# CITY OF ALBUQUERQUE

August 3, 2016

**Re:** Sigma Chi Parking Lot  
**1835 Lomas Blvd NE**  
**Traffic Circulation Layout**  
Engineer's Stamp 08-02-16 (J15D098)

ENGINEER'S SEAL  DAVID SOULE P.E. #14522	NORTH 70' OF LOT 7, 8, 9, BLOCK 4 SIGMA CHI ADDITION	DRAWN BY JDG
	TRAFFIC CONTROL LAYOUT	DATE 11-18-2016
 Rio Grande Engineering 1606 CENTRAL AVENUE SE SUITE 201 ALBUQUERQUE, NM 87106 (505) 872-0999		SHEET # 1 OF 1
		JOB #

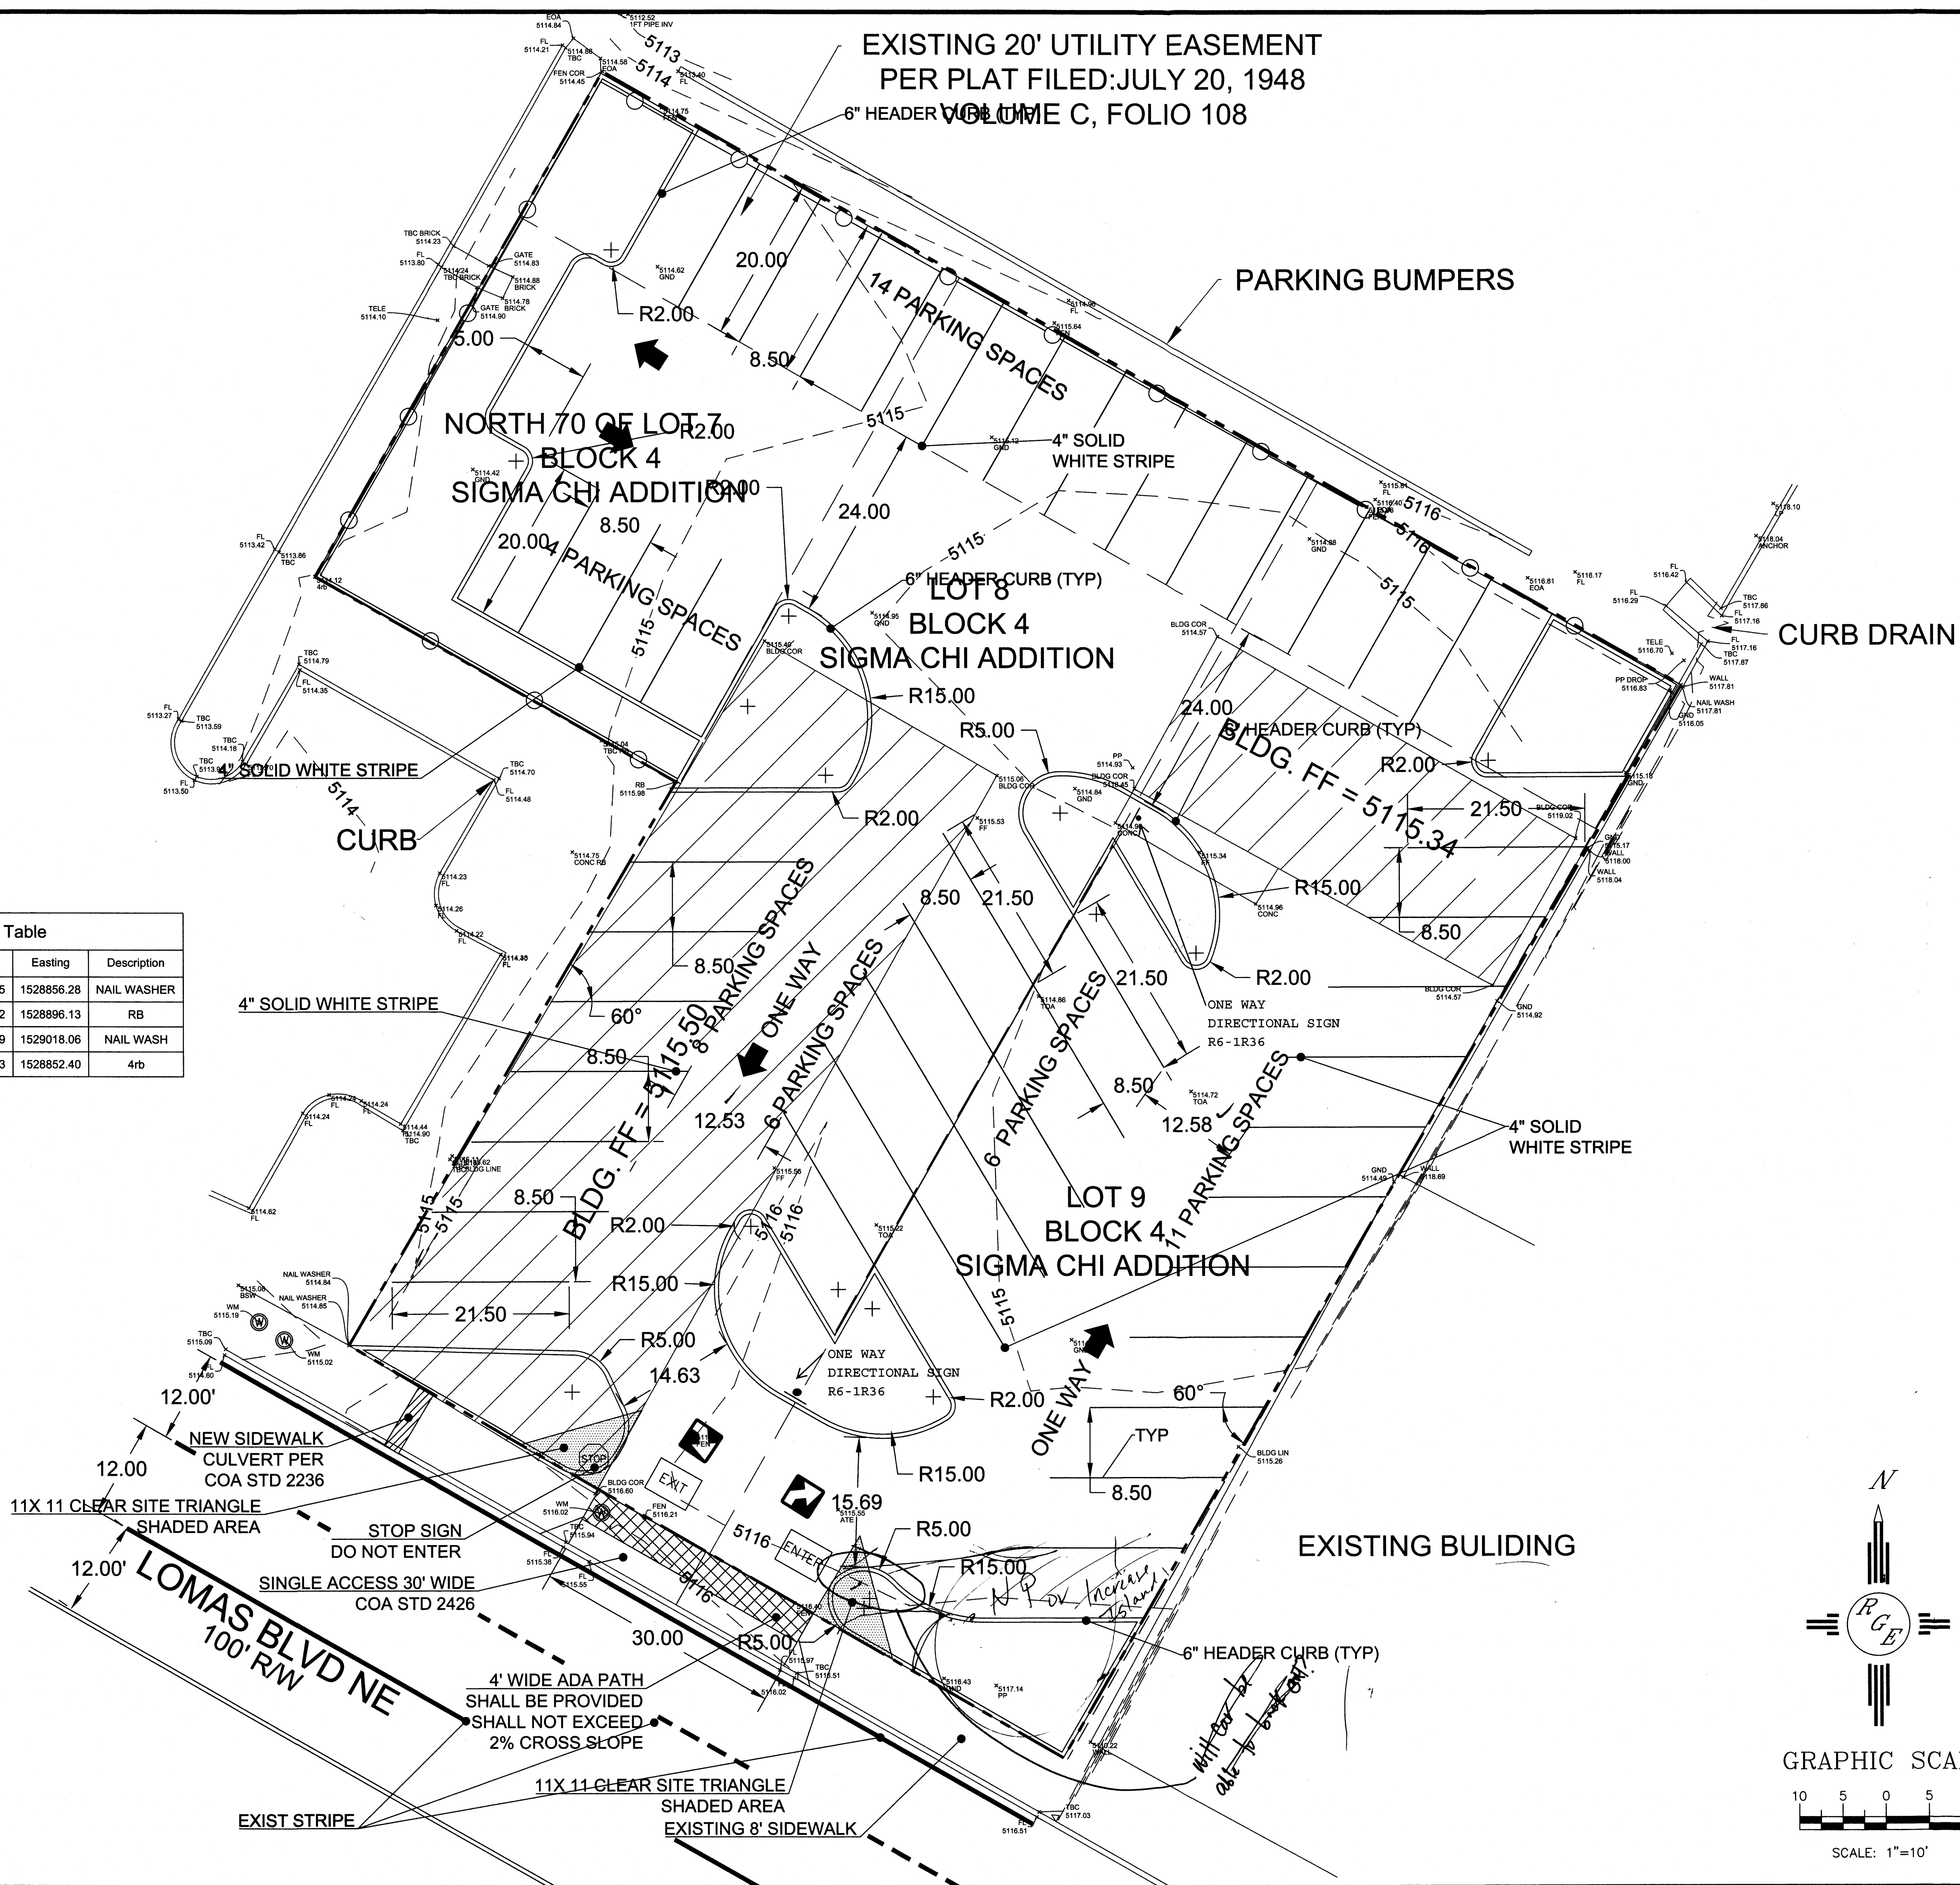
1. Please review and revise plan to provide all information listed on the attached Traffic Circulation Layout Check List.
2. Please refer to the attached Accessible Parking Checklist and revise the plan accordingly.

3. List the number of parking spaces required by the zoning code as well as the proposed number of parking spaces.
4. Please identify all existing buildings, doors, structures, sidewalks, curbs, drive pads, wall and anything that influences the parking and circulation on the site.

5. Identify the right of way width, medians, curb cuts, and street widths on Lomas Blvd.
6. Please provide grades and slopes of the parking area and or the handicap accessible parking.

7. Please list the width and length for all proposed angled parking spaces. Call out the degree in which the spaces will be angled.
8. The handicap accessible spaces must be a minimum of 8.5 ft. in width.

9. The handicap accessible spaces must include an 8 ft. wide van access aisle; all other aisles should be 5 ft. in width.
10. The ADA accessible parking sign must have the required language per 66-7-352.4C NMSA 1978 **"Violators Are Subject to a Fine and/or Towing."** Please call out detail and location of HC signs.

11. The ADA access aisles shall have the words **"NO PARKING"** in capital letters, each of which shall be at least one foot high and at least two inches wide, placed at the rear of the parking space so as to be close to where an adjacent vehicle's rear tire would be placed. (66-1-4.1.B NMSA 1978)

12. A 5 ft. keyway is required for dead-end parking aisles.

13. The curb on the Southwest corner is within the COA right of way. Please correct or provide an approved easement.
14. The 6" header curb in the Northeast corner of the property with a radii of 5' will need to be reduced to 2'.

15. Please call out and dimension motorcycle parking if required.
16. Per DPM, a 6 ft. wide ADA accessible pedestrian pathway is required from the public sidewalk and the HC parking stall access aisles to the building entrances. Please clearly show this pathway and provide details.

17. One-way vehicular paths require pavement directional signage and a posted "Do Not Enter" sign at the point of egress. Please show detail and location of posted signs.

18. It is not apparent what type of pavement surface is being proposed. A hard driving surface will be required as part of this proposed project for parking area and drive aisles.

19. Please provide a sight distance exhibit (see the *Development Process Manual, Chapter 23, Section 3, Part D.5 Intersection Sight Distance*).
20. Please add the following note to the clear sight triangle: "Landscaping and signage will not interfere with clear sight requirements. Therefore, signs, walls, trees, and shrubbery between 3 and 8 feet tall (as measured from the gutter pan) will not be acceptable in this area."

21. See Chapter 23, Section 6 of the City of Albuquerque *Development Process Manual*, for appropriate drive pad widths.
22. All broken or cracked sidewalk and driveways must be replaced with sidewalk and curb & gutter. All driveways and sidewalk must meet current ADA standards. A build note must be provided referring to the appropriate City Standard drawing.
